**CITY OF PORTLAND, MAINE**  
**HISTORIC PRESERVATION BOARD**

September 6, 2016

Re: 135 Park Street  
CBL: 039 A014

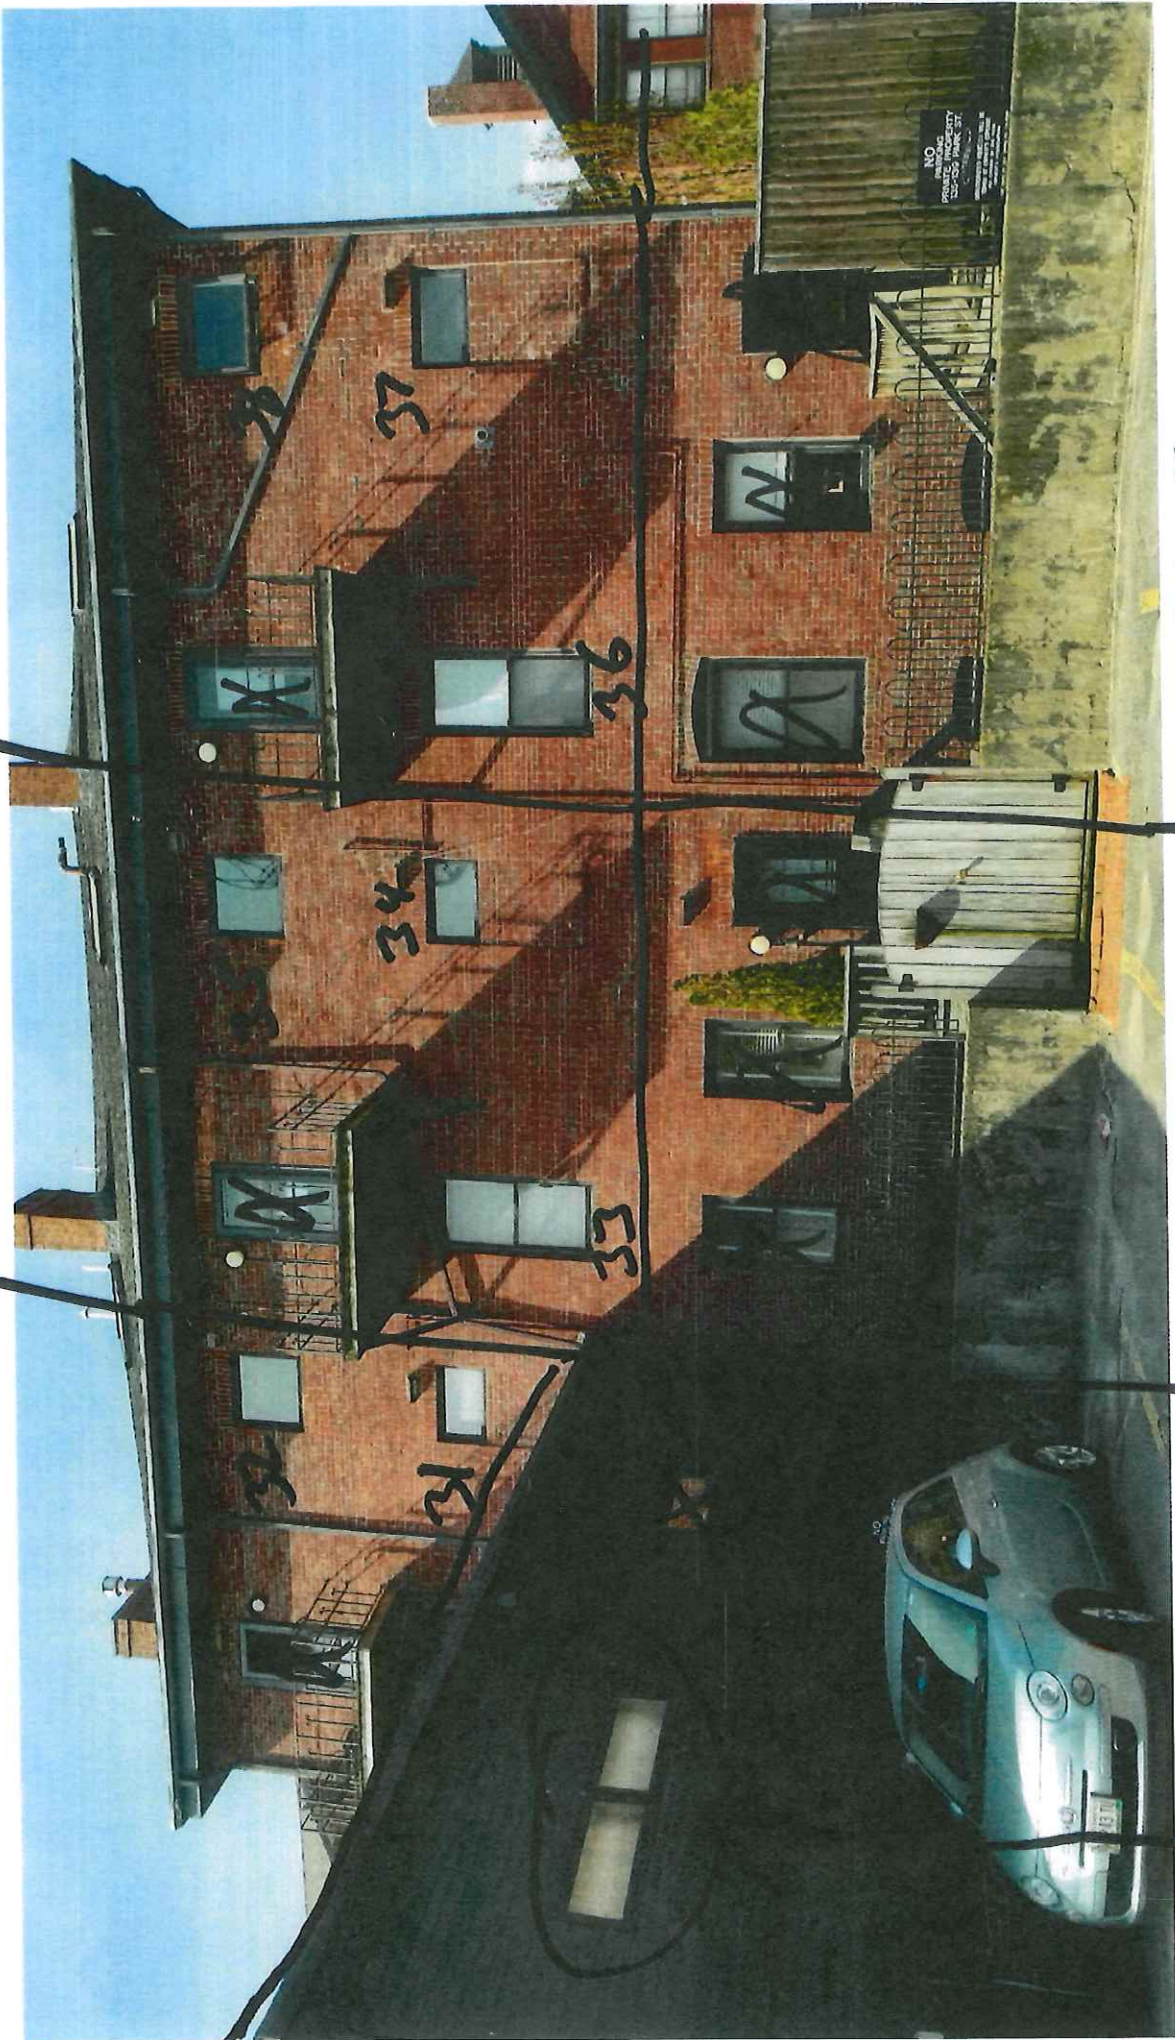
This office has approved your application to replace twenty-six windows on the front (24) and southeast end (2) of your property at 135 – 139 Park Street. Approval is based on the plans and specifications included in the application dated June 3, 2016 (revised window specifications supplied later by Rufus Deering Company and by Kent Gordon,) and is subject to the following conditions:

1. HP staff understands the windows are to be Jeld-Wen full-unit (not inserts) clad windows in black, with 5/8" putty glaze profile muntins - simulated divided lights (SDL) on the interior and exterior, with spacer bars. It is understood that the first and second floor windows will be 6/6 and the third floor windows are to be 3/3.
2. If screens are desired they are to be half screens.
3. Visual transmittance of the glass (VTR) is to be .7 or greater, so glass appears clear, untinted, and non-reflective.
4. Painted wood casing and brick mould is to be reproduced on site after window installation, with approximately 2" of flat casing with a staff bead moulding (Brosco B691) on top, at the edge of the masonry opening.
